Your Ref: OWPC15460
Our Ref: FG/135/17/PL 18-08-2017
Please ask for:
Mrs A Gardner

Erection of 1 no. 2 bed dwelling
South Point Beehive Lane Ferring

Thank you for your internet representation made on 4th September 2017 which has been recorded as '**an objection**' with the comments as follows:

Proposed Block Site Plan - 1:200 @ A1

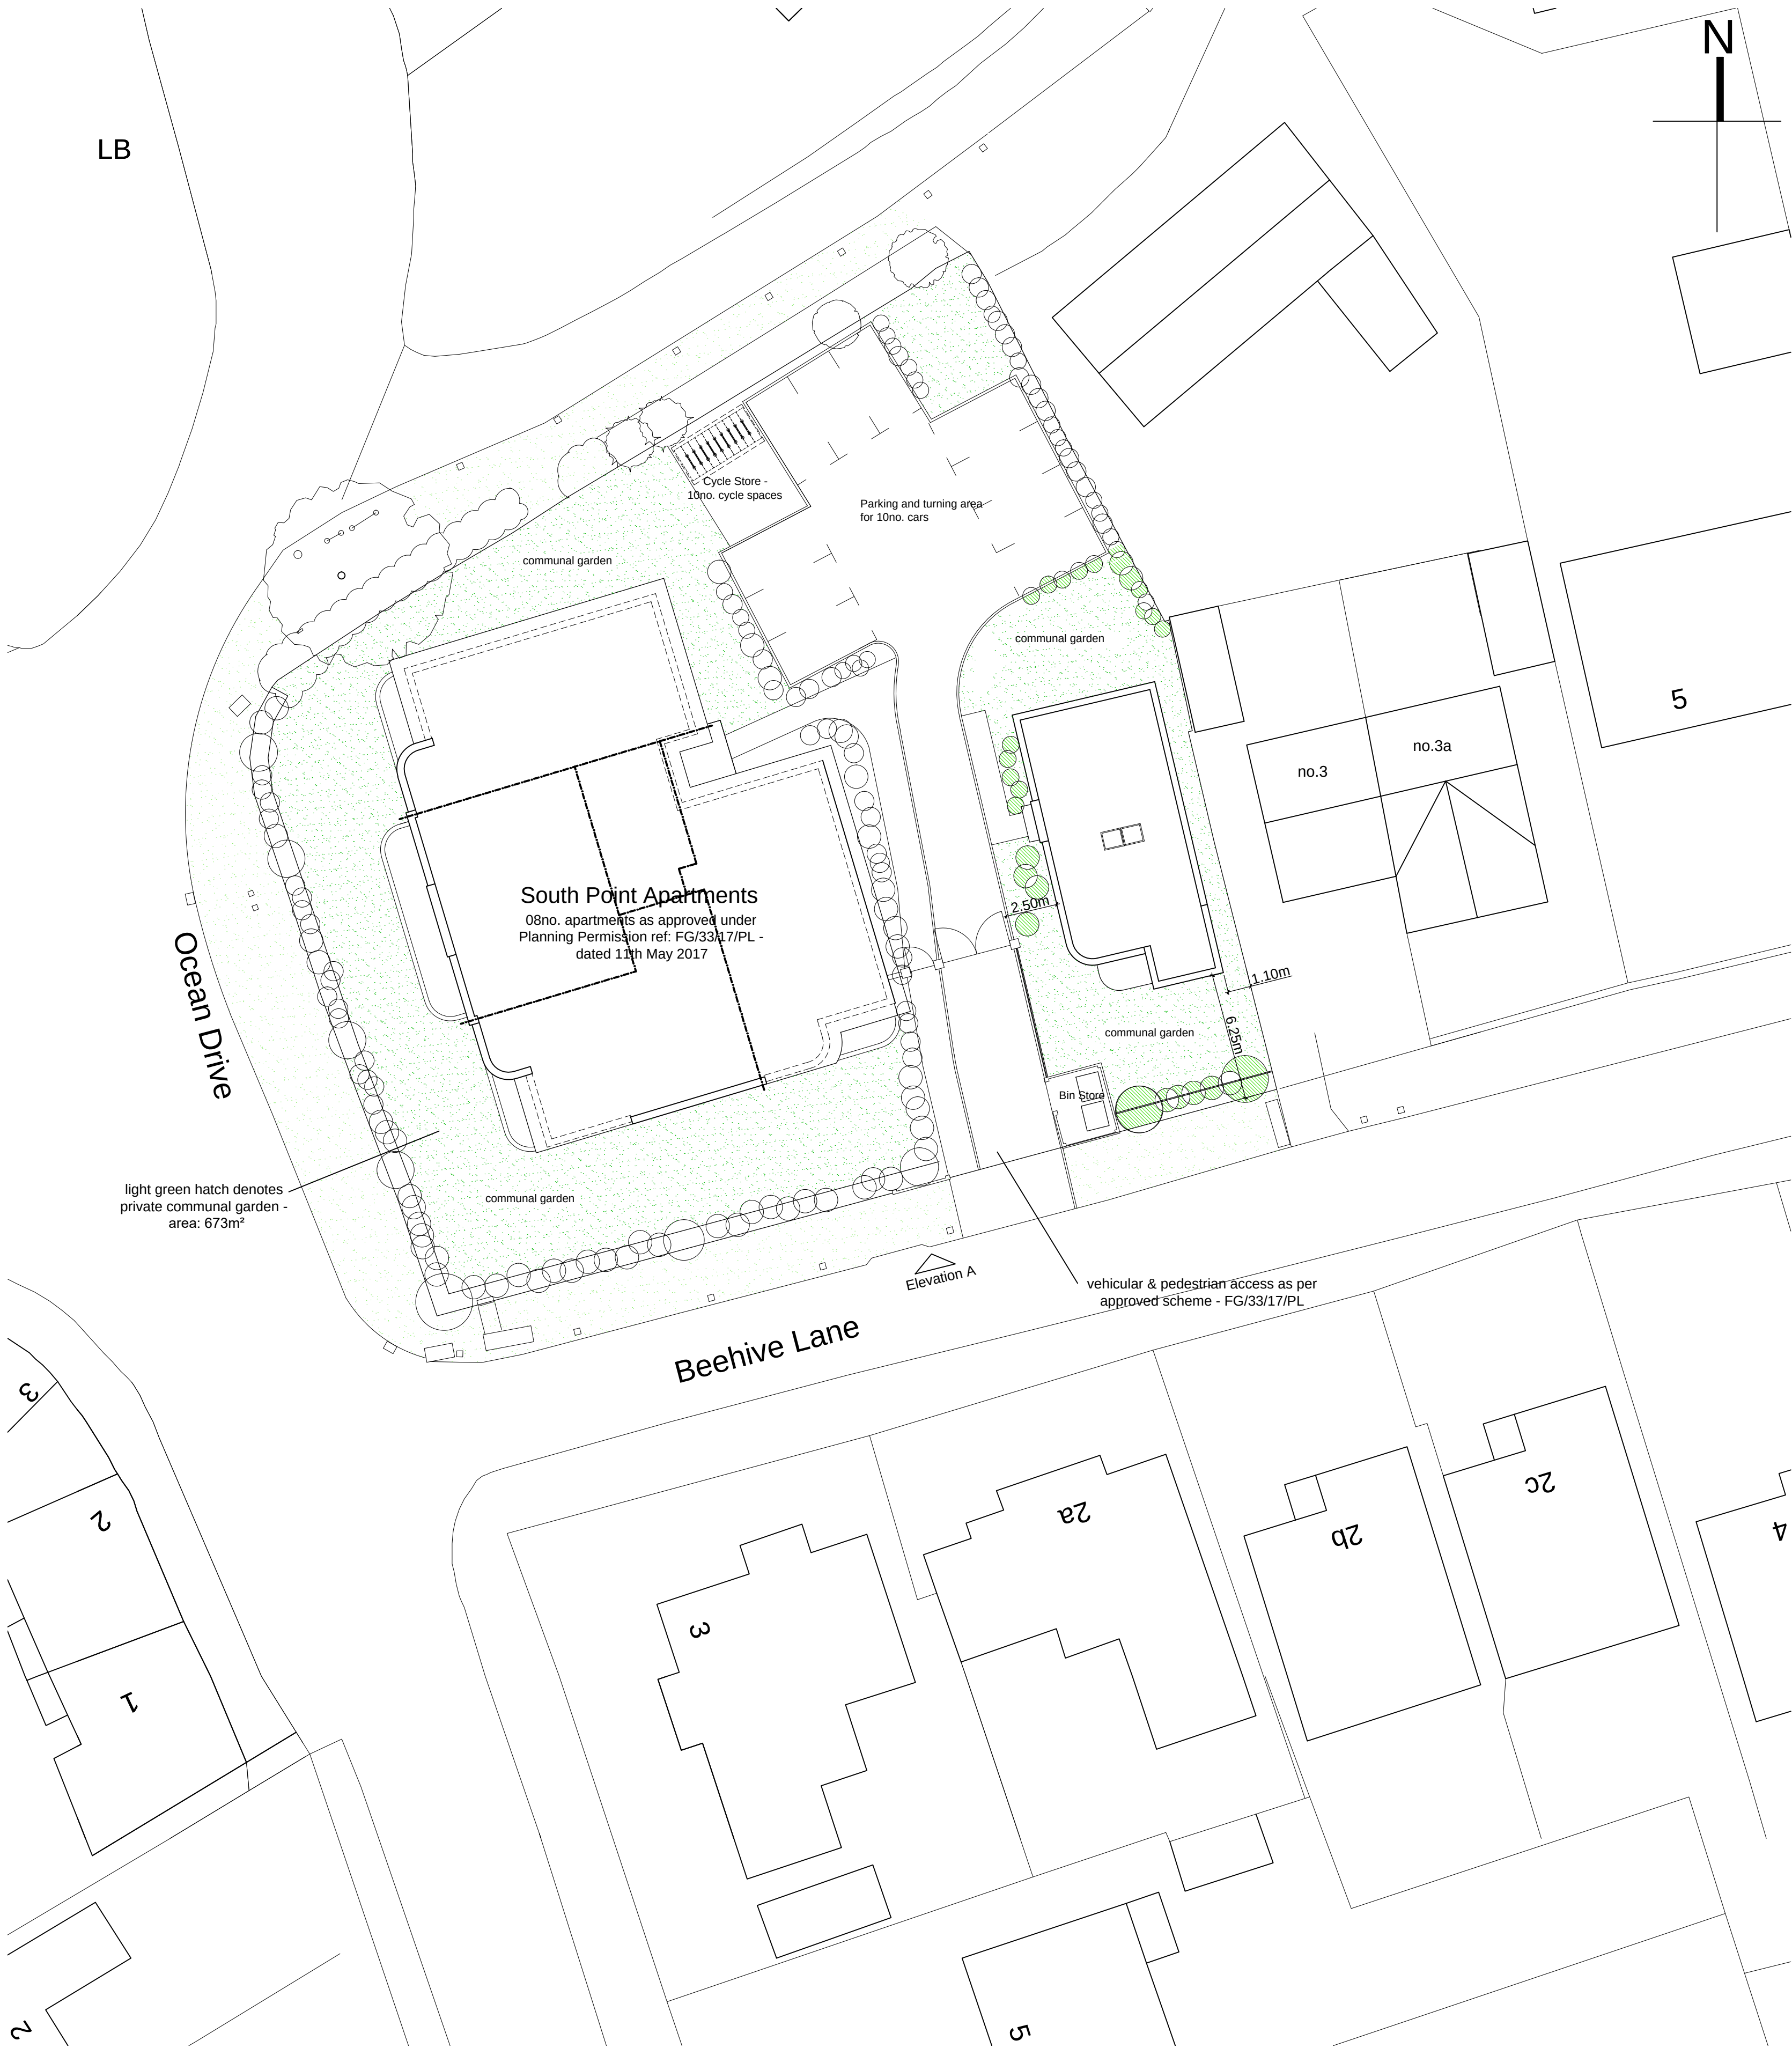
An already over developed site. This application is a cynical attempt to over pack the land with buildings, remove the approved communal gardens and deprive local residents of open spaces. It also directly contravenes the recent changed approvals for this development.

Parking remains an issue as there is no off street parking available and with only 10? spaces for 9 apartments, where are all the vehicles going to be parked in addition to delivery vehicles and emergency responders?
